RE: Marian Meadows Development Agreement (DV-19-00001) – Second Review and Request for Corrections/Additional Information

RE: Marian Meadows Development Agreement, December 2019

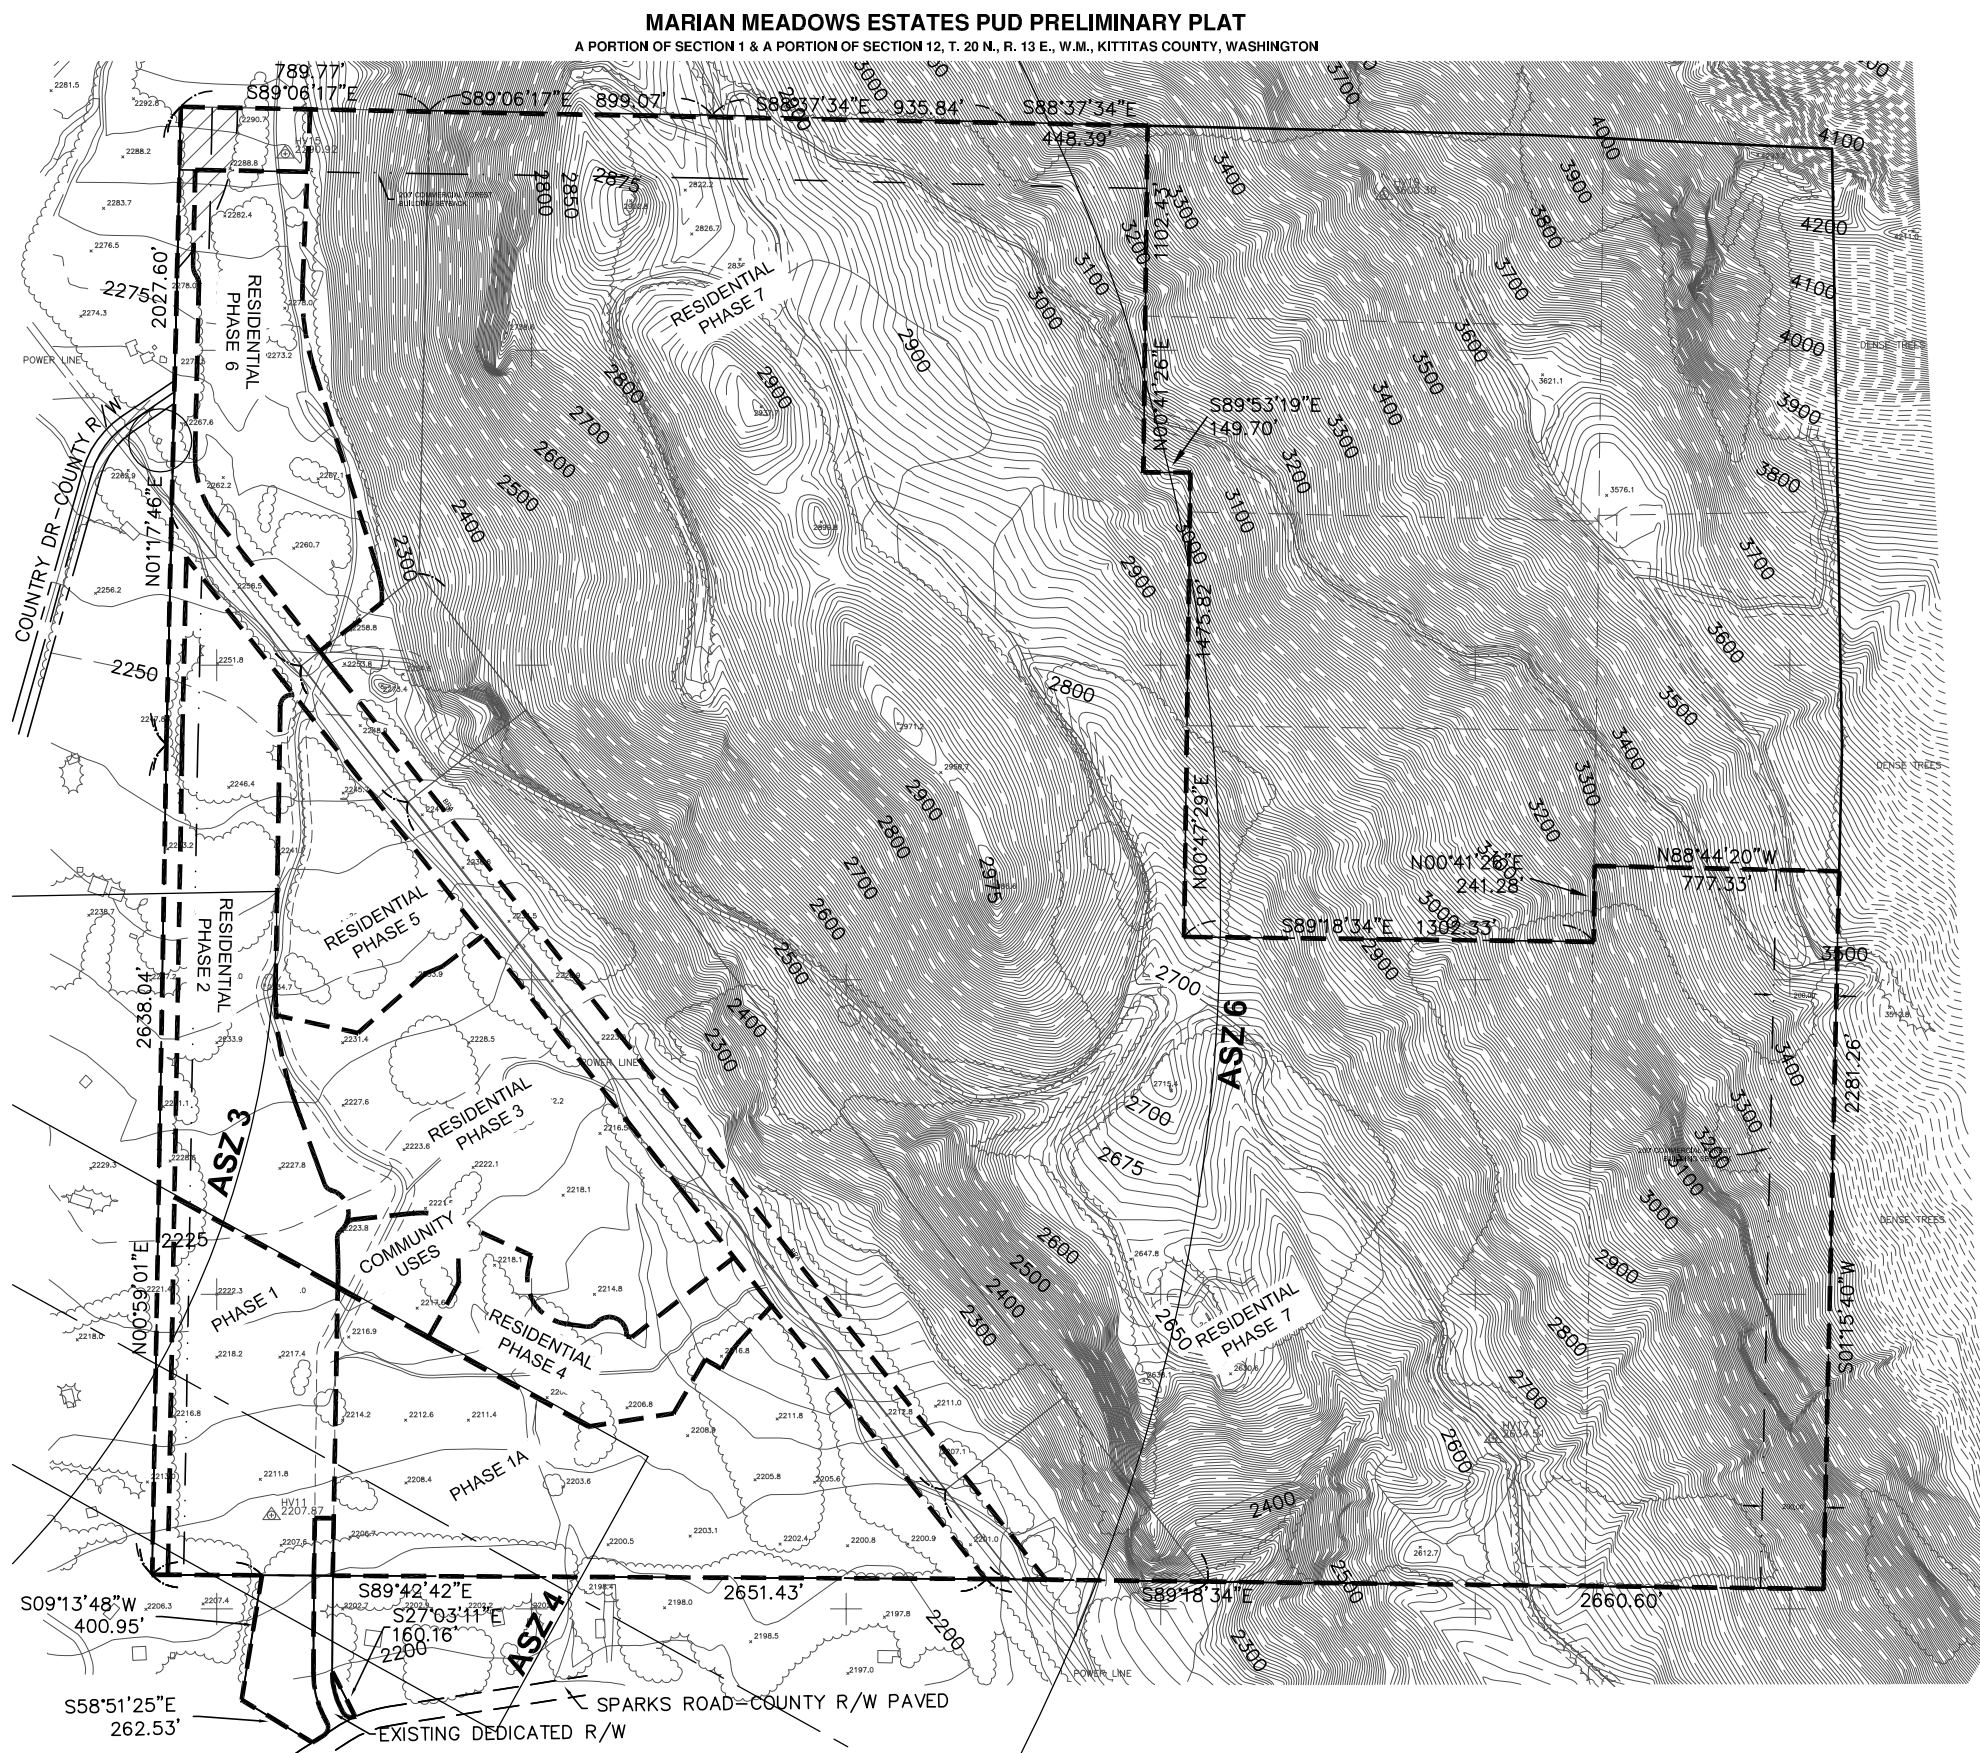
CDS Staff acknowledges that the provided engineering documents (plat layout) show the 200 foot commercial setback as requested, however the Community Standards and Guidelines document now provided as Exhibit E of the resubmitted packet do not reflect the Commercial Forest Setback of 200 feet from property lines abutting lands zoned Commercial Forest. This affects the northern and eastern boundaries of the Marian Meadows PUD and shall be reflected in the Community Standards and Guidelines document.

In response, we presume the inch (") symbol should be foot symbol ('). Public Works will not accept any tract of land separate from the right-of-way for snow storage. The minimum right-of-way width supporting snow storage is eighty feet (80'). All public roads require supporting land dedication to Public Works.
